MECKLENBURG COUNTY
Park and Recreation Department

MEMORANDUM

DATE: October 19, 2020

RE: Rezoning Petition #2020-125 – Back Creek Townhomes

**RZ-1.0**

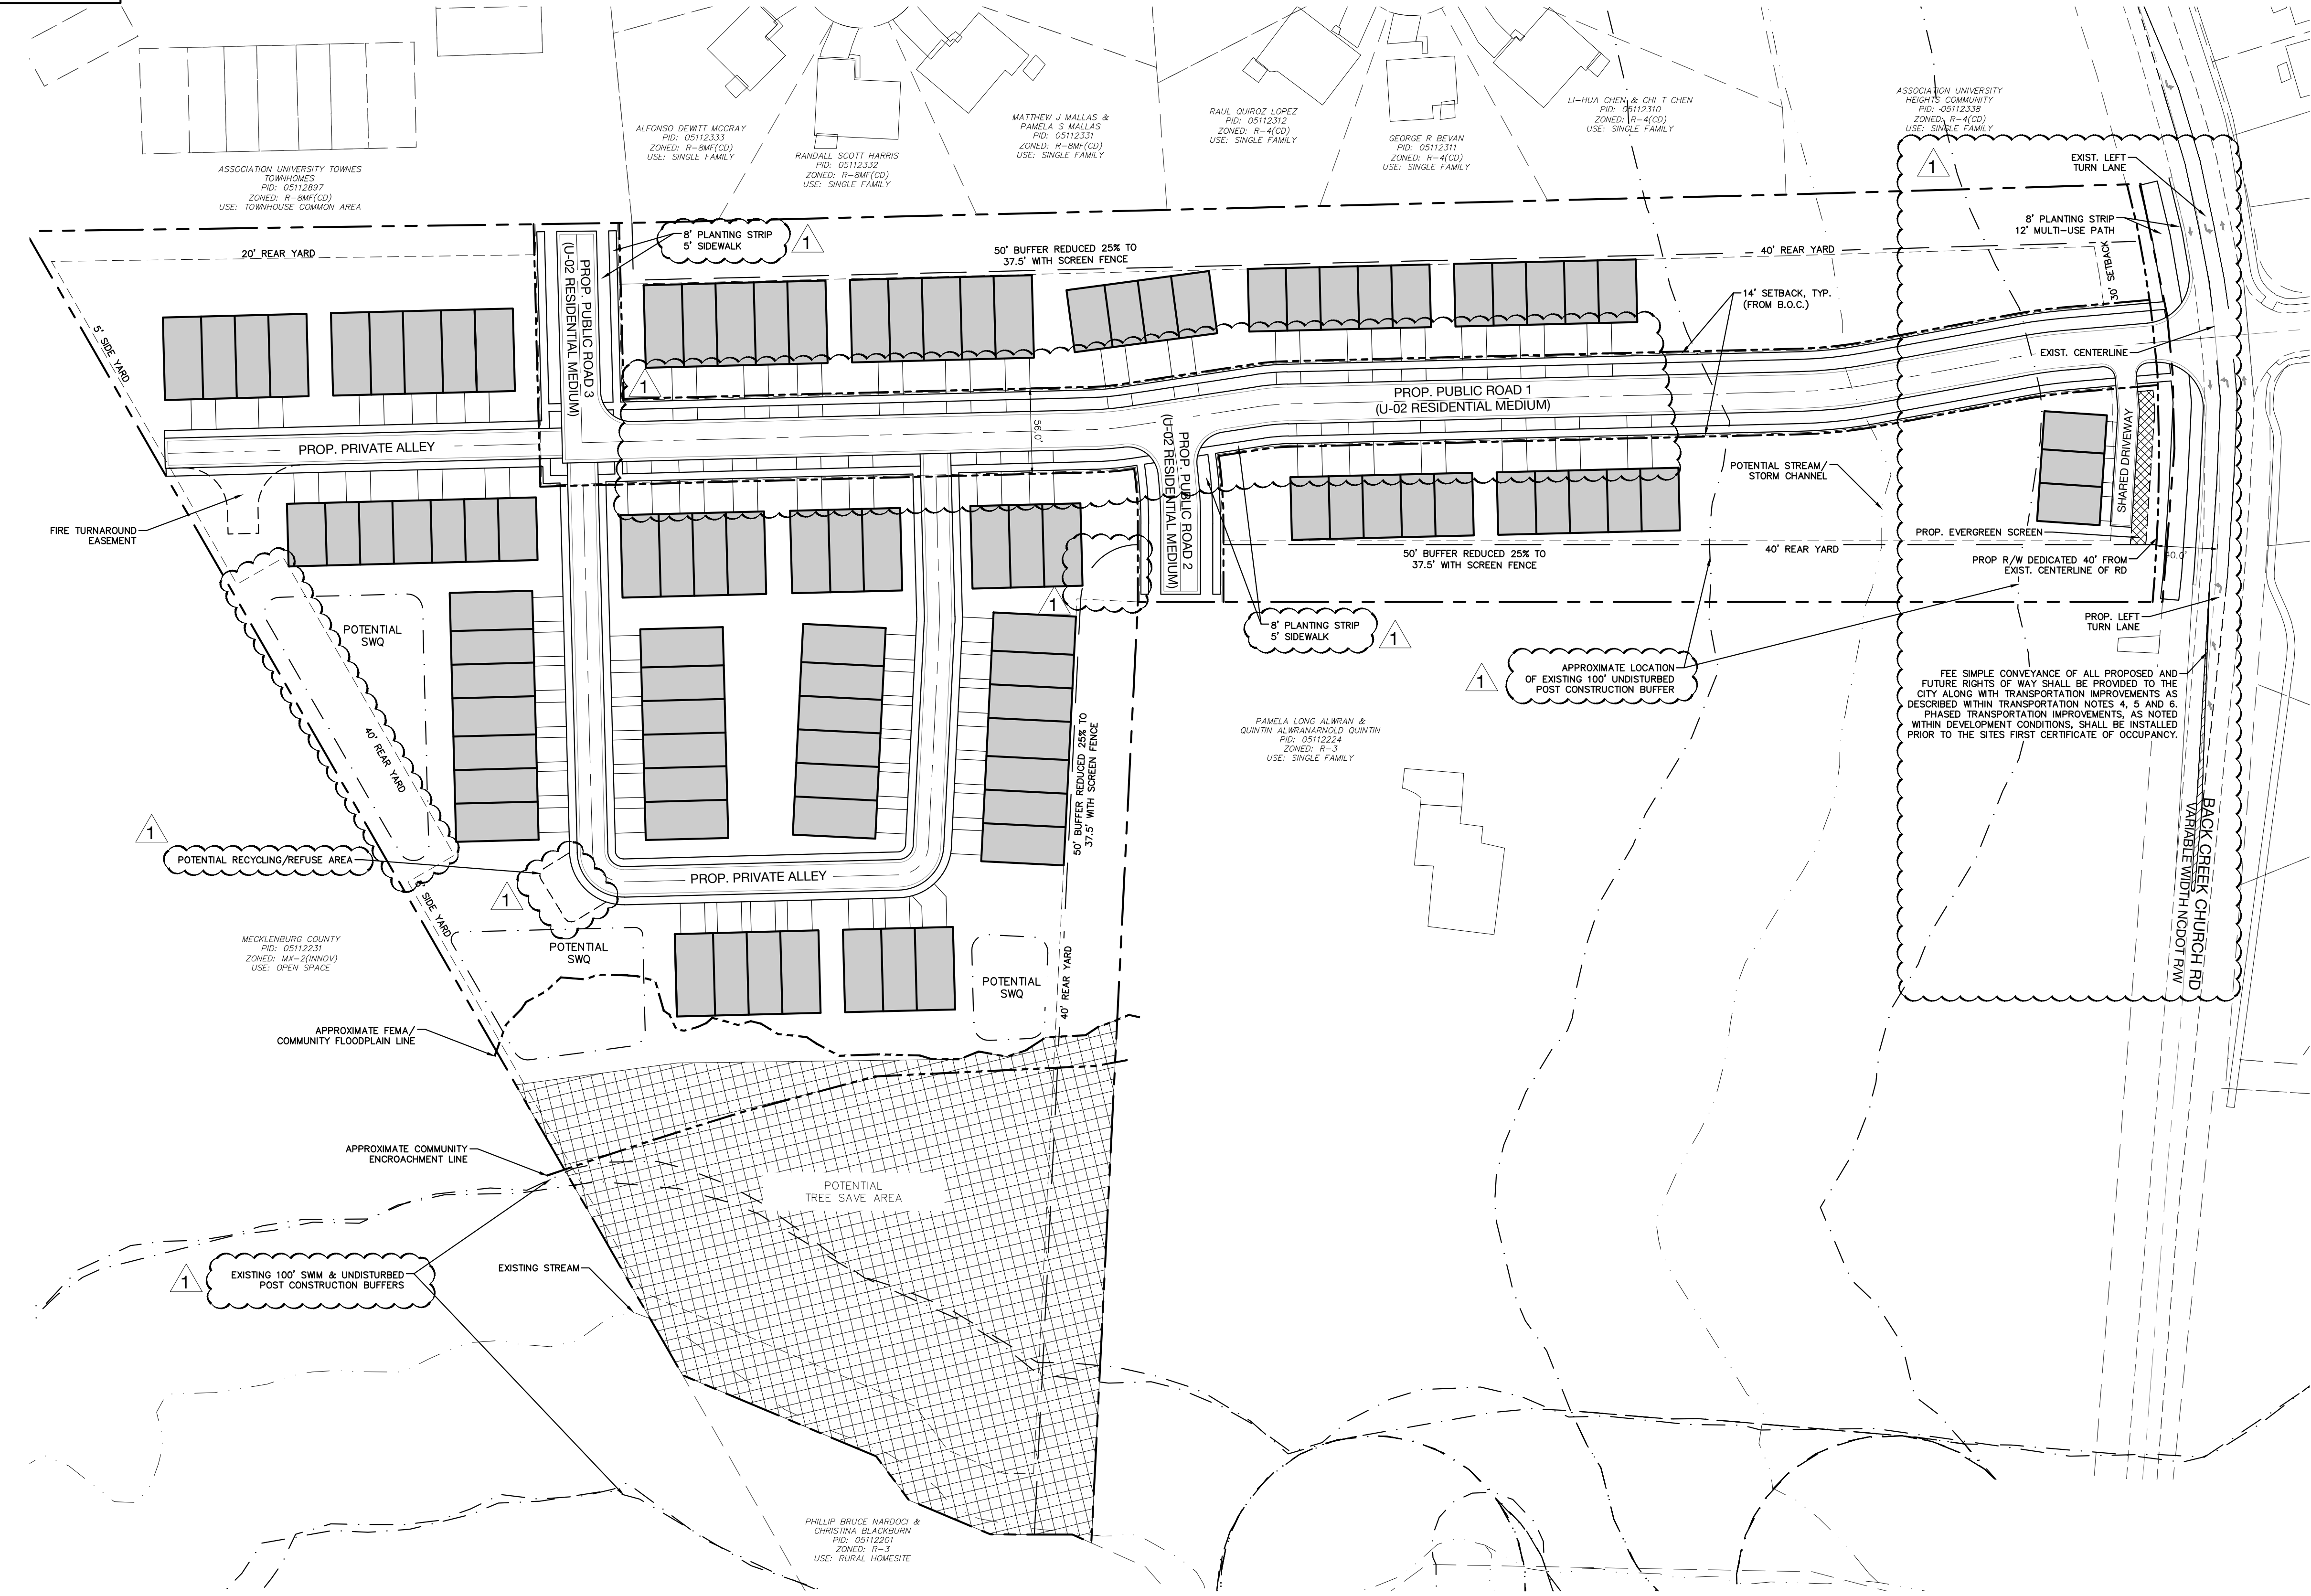
MCPR requests the petitioner dedicating and conveying or providing a greenway easement of the same area to Mecklenburg County - the 100' SWIM Buffer of Back Creek. This parcel is on the MCPR Greenway Master Plan.
